# CITY OF ALBUQUERQUE

Re: **Play House Learning Center**  
**809 Old Coors Dr. SW**  
**Traffic Circulation Layout**  
Architect's Stamp date 2/3/2021 (L11D069)

SHEET NUMBER
FIRE 1.0

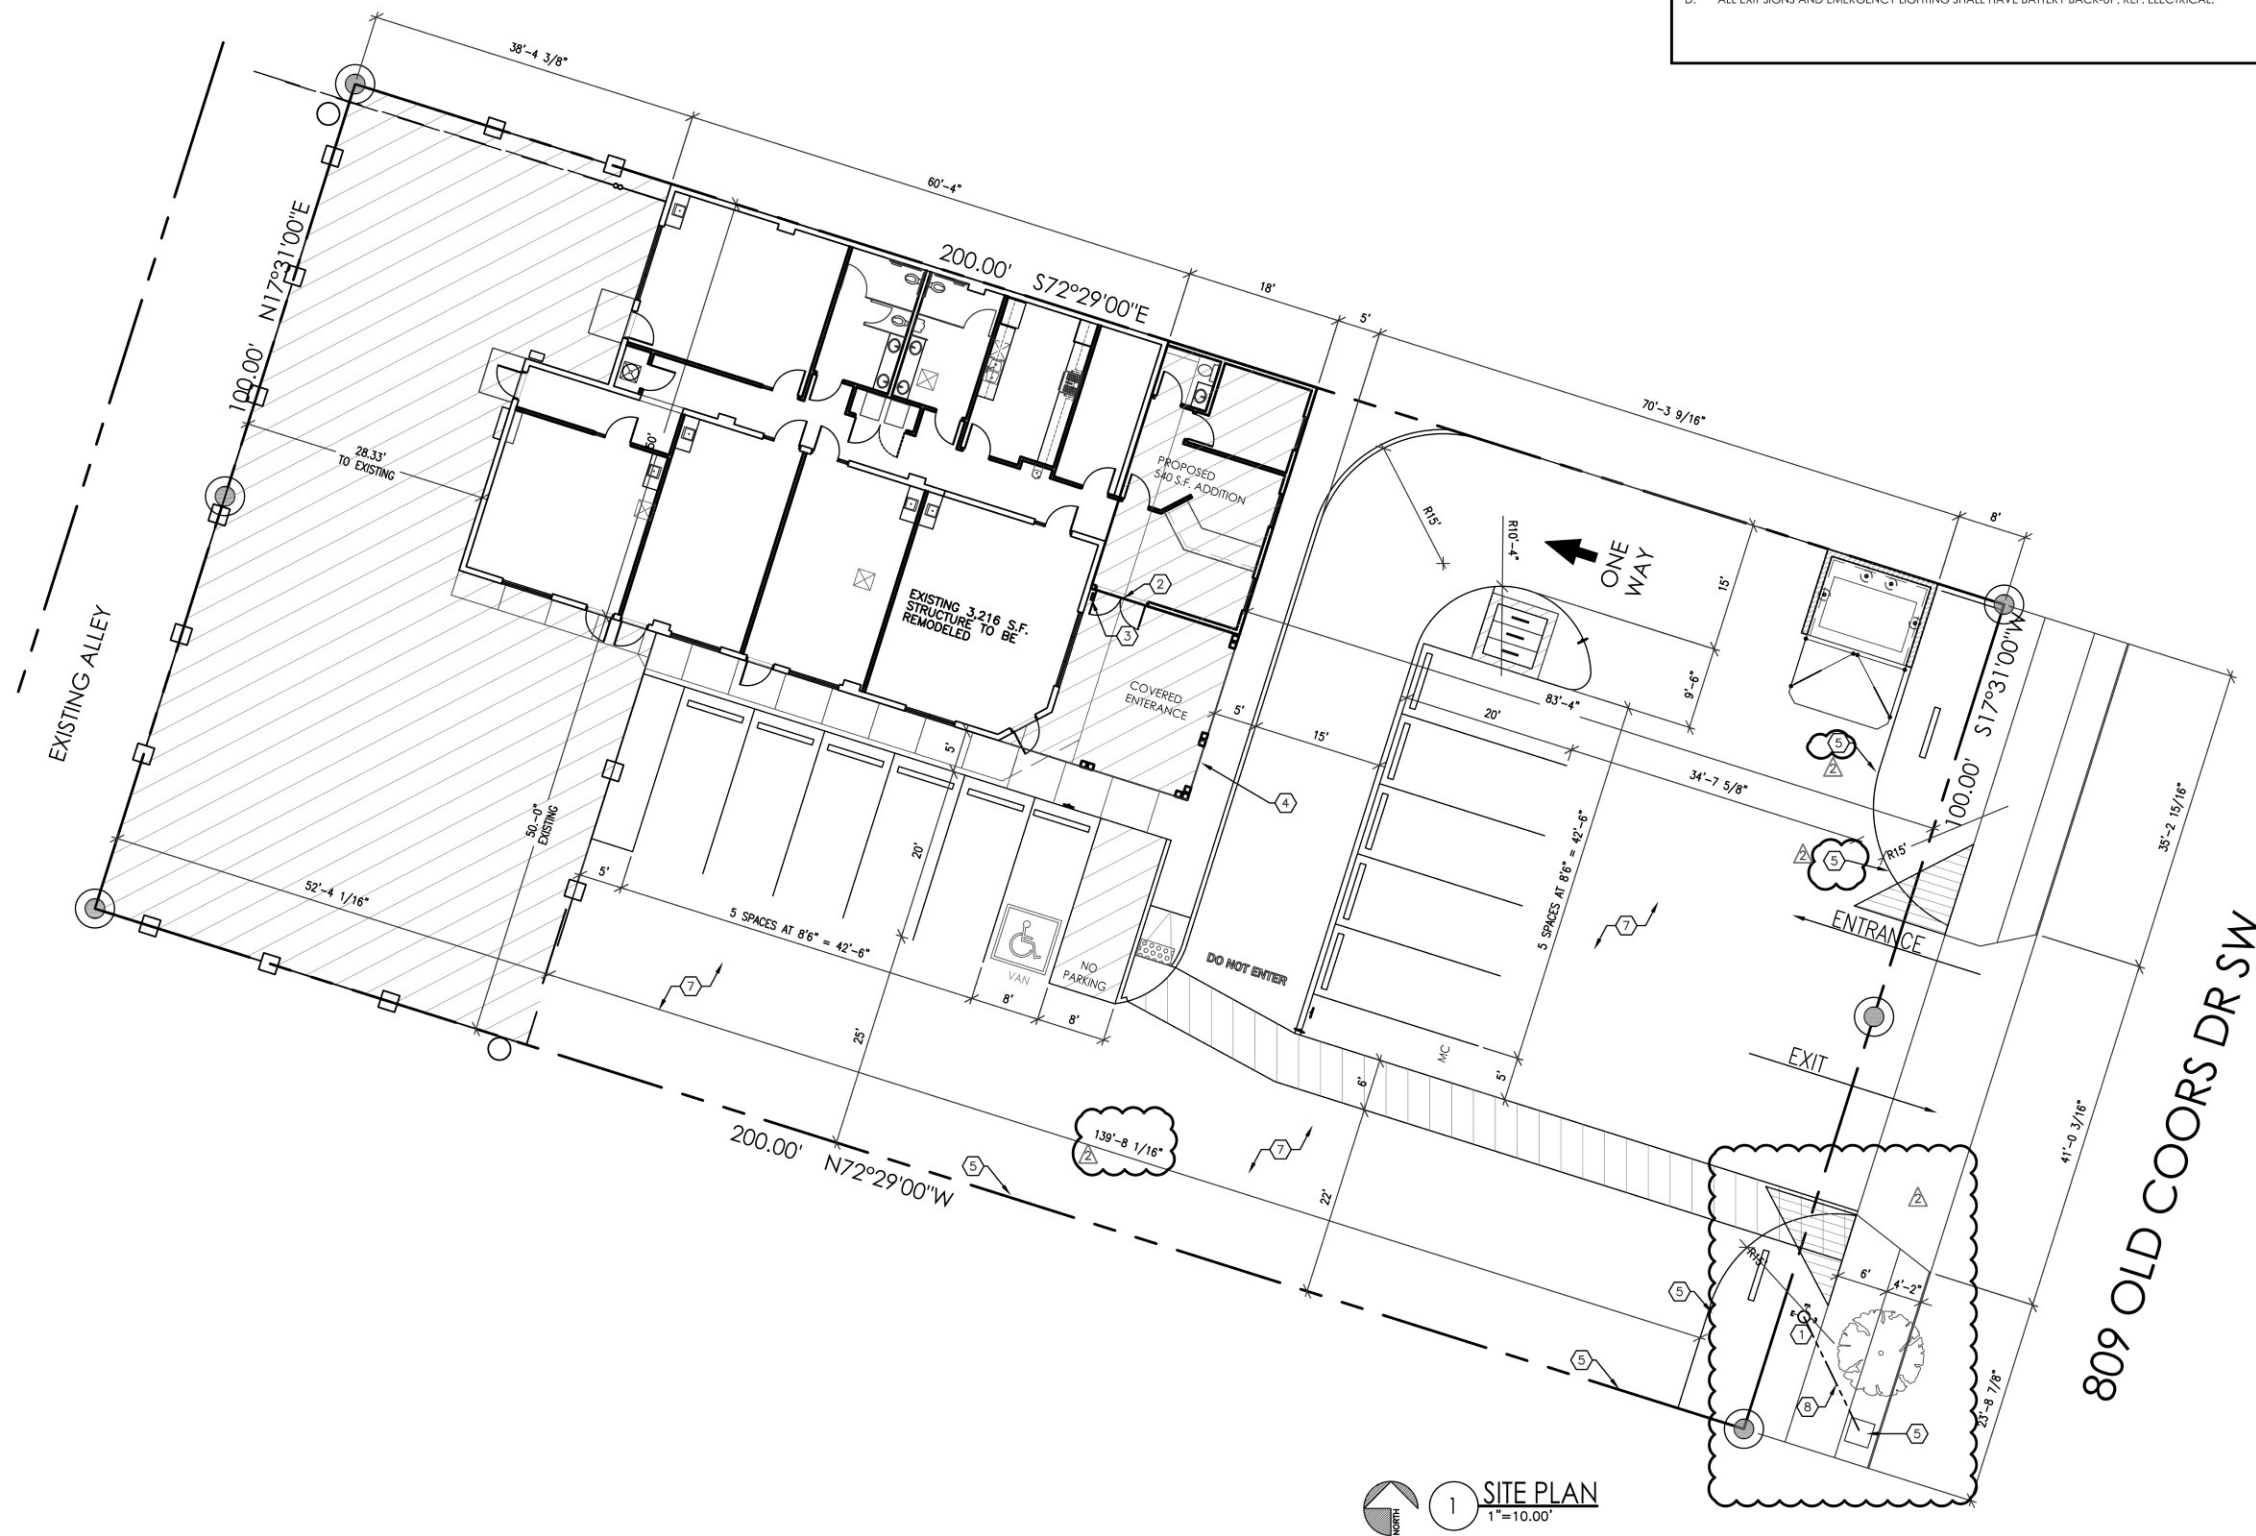
4. Provide a 5 feet wide key way (4'-4 3/8" on the plans) for the last parking space to the west. It is next to a fence.
5. Provide details for drive pad. Show the drive pad width and lanes.

6. Show all easements. If none state so.
7. Include one-way and do not enter signs for one-way traffic. Minimum width for two-way traffic is 22 feet.
8. Fire and emergency access: Provision for access by fire and emergency vehicles needs to be in accordance with the Albuquerque Fire Plan Checking Division. Provide approval from the Fire Marshall.

9. Include motorcycle parking sign detail and location.
10. Driveway sight distance problem; tree south of the driveway should be pruned so that the lowest branches are 8 feet or greater above sidewalk elevation.

11. Hatching question; are these ADA warning surfaces? They are not being used correctly and the size is not correct, see attached drawing.
